From: Laura Gibbons
Sent: 12 April 2019 12:16
To: Simon Davis <Simon.Davis@arun.gov.uk>
Subject: RE: Y/9818/RES and Y/97/18/DOC

Comments on the revised drainage and landscape proposals:

Job Title			
LAND SOUTH OF BURNDILL ROAD, YAPTON			
Drawing Title			
PRELIMINARY ENGINEERING LAYOUT			
Client			
BOVIS HOMES			
Scale	Date	Designed	SG
1:500 @A1	NOV 18		
Drawn	Checked	Approved	RS
SOM	LH		
Job No	Drawing No		Rev
18-070	18-070/103		P

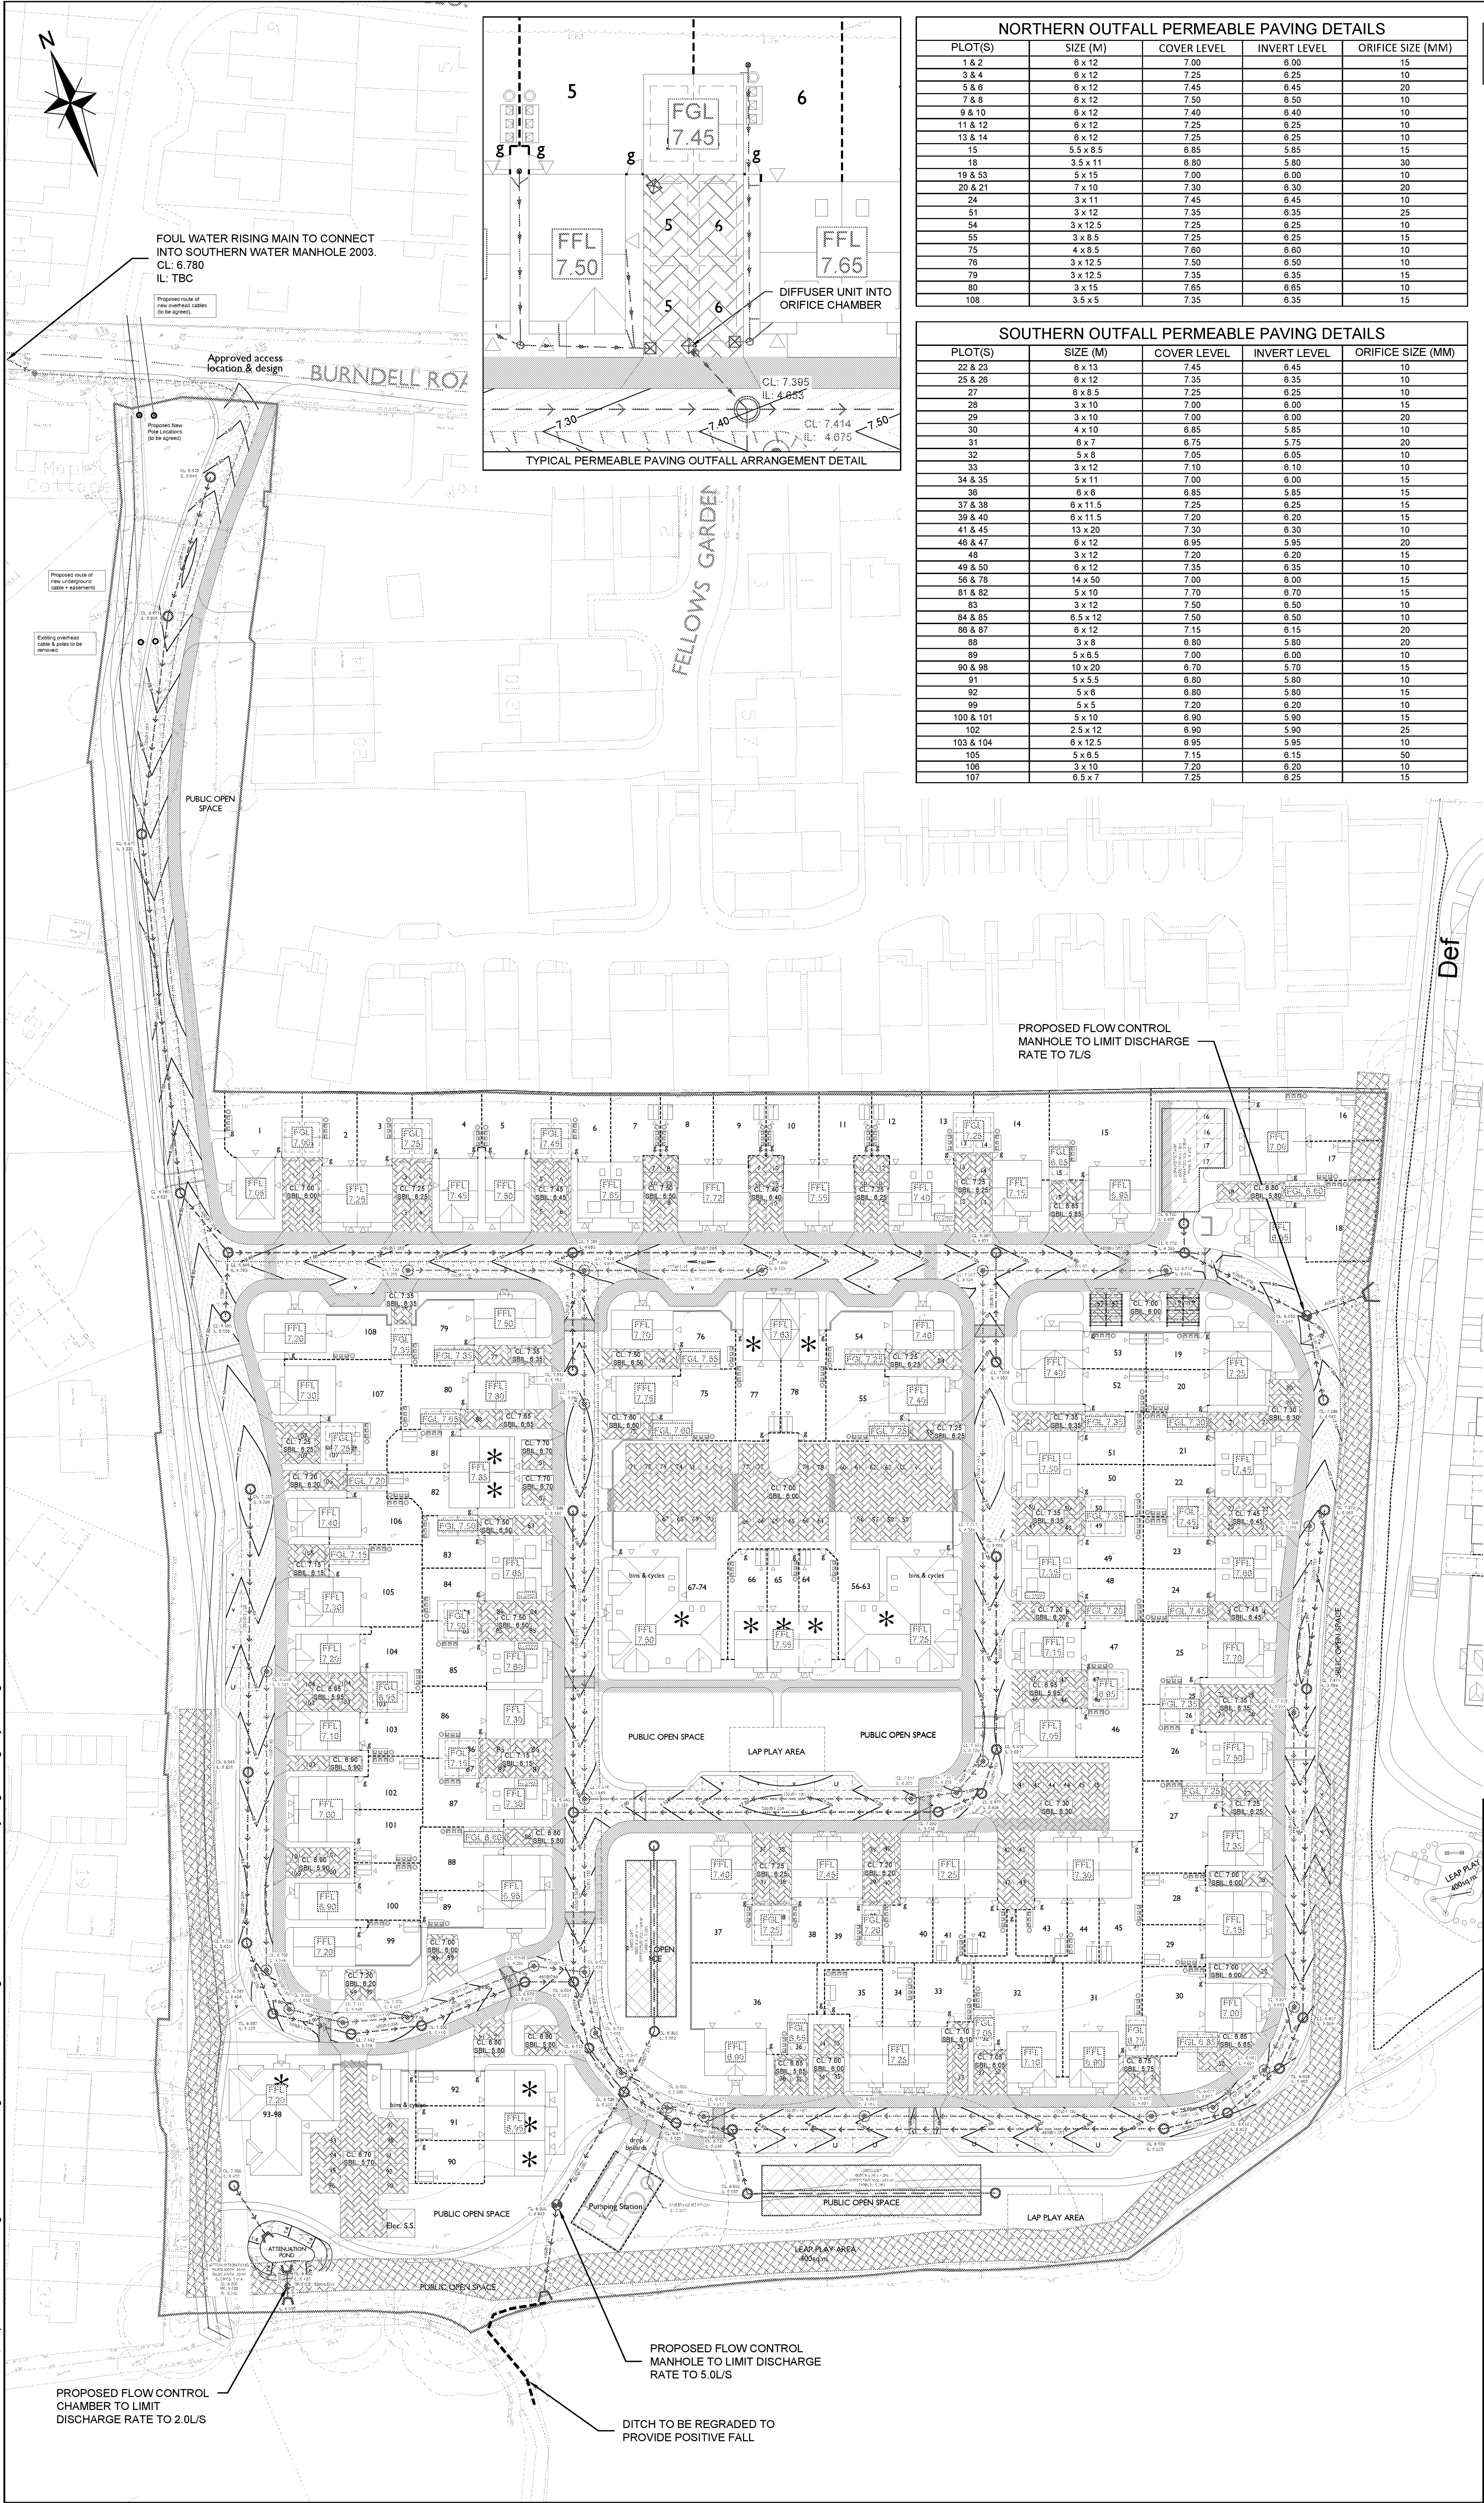
1. There are still trees proposed in close proximity to the southern-most attenuation tank.
2. A ground investigation report has been provided which details how groundwater monitoring was conducted November to December 2015. Peak ground water levels within this window were 1.64m bgl near the proposed location for the attenuation pond. Winter monitoring is required to be completed October to March inclusive. This is required even when infiltration is not proposed to ensure that the effects of flotation are adequately accounted for in design.

4. Top of bank levels, invert levels and slope need to be labelled on proposed ponds.
5. Proposed invert levels of outfalls to ditches appear to be low in comparison to surrounding bed levels. A minimum of 150mm must be provided between the invert level of outfall and ditch bed level.

6. Details of how the permeable paving links to the main drainage system have not been provided.
7. Construction detail drawings need to be provided. I recommend that the applicant refers to our checklist for further detail of our requirements.
